Application no: 23/00916/DISC

Location: Heyford Park, Camp Road, Upper Heyford, OX25 5HD

Transport Development Control

HEYFORD PARK - PROPOSED CAT AND DOG PROOF FENCE (CONDITION 14)

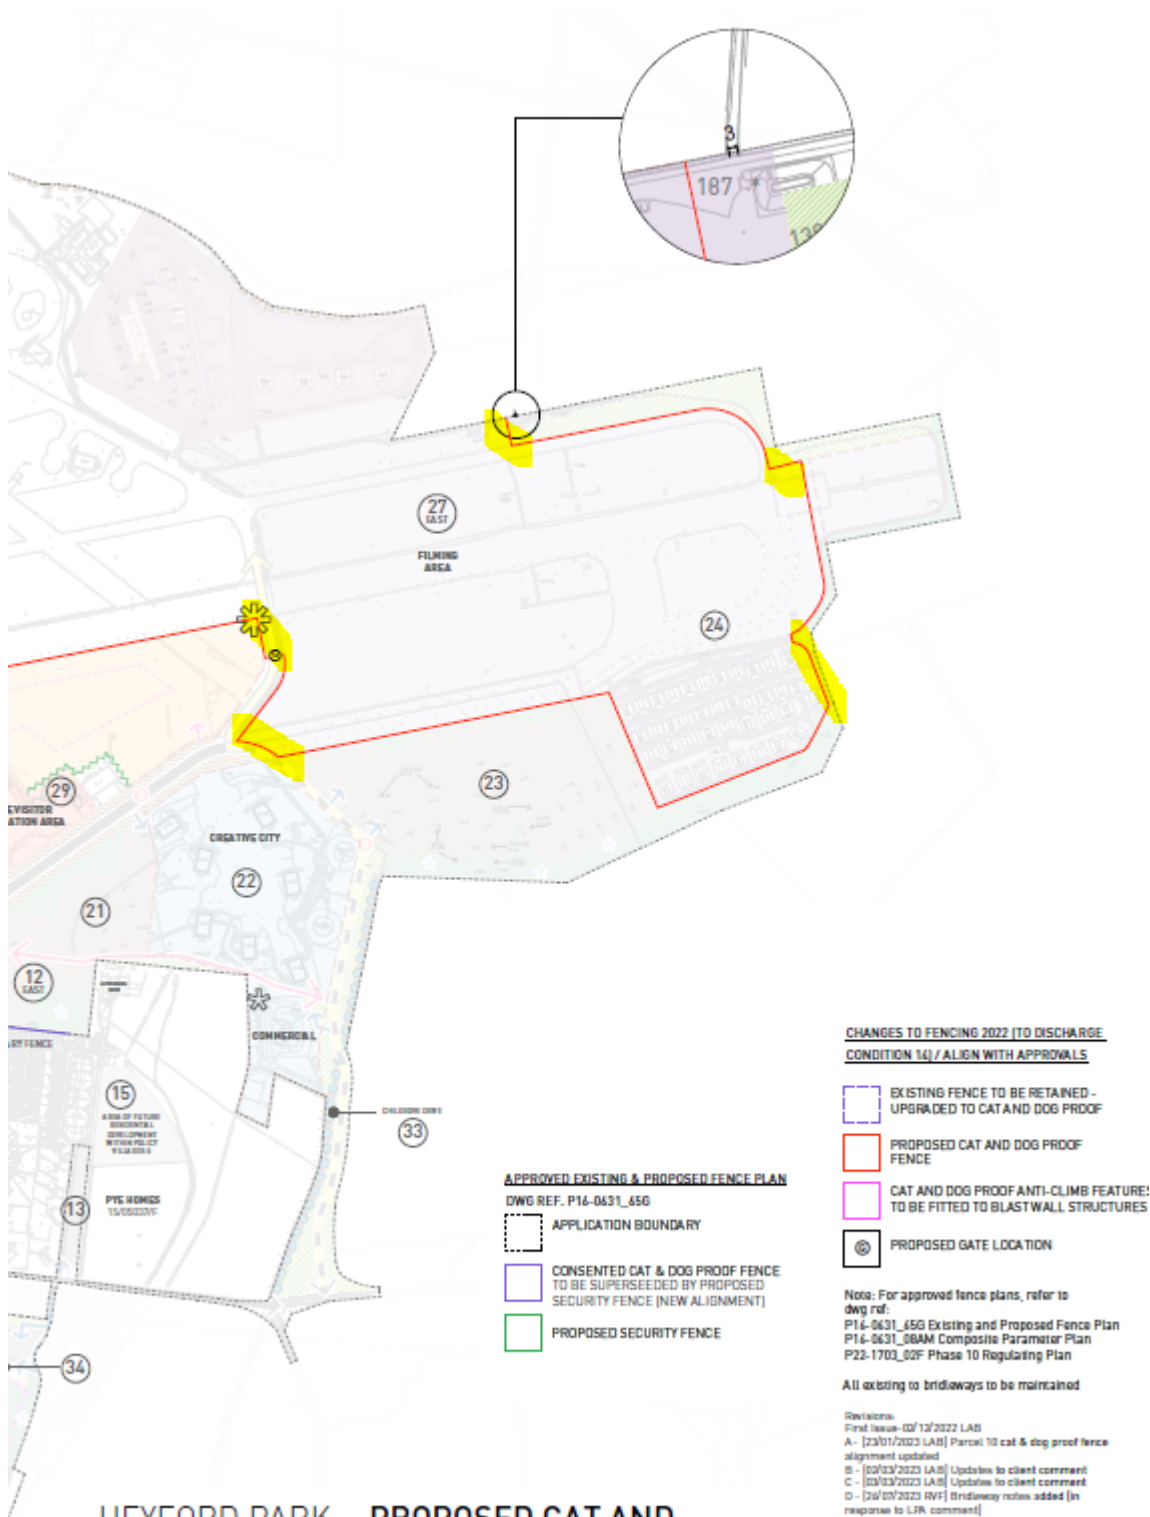
The Fencing Strategy has implications for public rights of way requirements. It does not provide for the perimeter fence to be changed to reflect:

- The requirement to reopen Aves Ditch. This was condition 30 on the 2011 planning permission (and in the S106 agreement) and required details of the Aves Ditch route to be submitted within three months of that planning permission and implementation within 18 months of that. **Despite repeated reminders, details have still not been submitted, 12 years later.** Aves Ditch is a critical local bridleway link that must be reopened in the interests of sustainable transport connectivity and affording leisure opportunities to local people that are currently denied to them. OCC expect that CDC will not discharge condition 38 of 18/00825/HYBRID until this is resolved.

- The requirement relating to the Heritage Trail on the northern perimeter of the flying field, where the legal line of footpath 349/13 (which forms part of the trail) runs inside the boundary. The perimeter fence must be moved to accommodate the legal line of the footpath or Dorchester must negotiate a diversion by working with neighbours. If progress is being made towards the latter, this must be referred to in the strategy and the strategy must be conditional upon this, with regard to a requirement to move the perimeter fence. OCC require an update on this matter. Whilst unresolved, this is again denying legitimate leisure opportunities to local people.

- The opening up of the extension of Chilgrove Drive, which is to form the main bus and HGV route into the development. This will necessitate widening the opening in the fence.

It also does not acknowledge Portway bridleway, which has already been opened and fenced off across the western edge of the flying field.
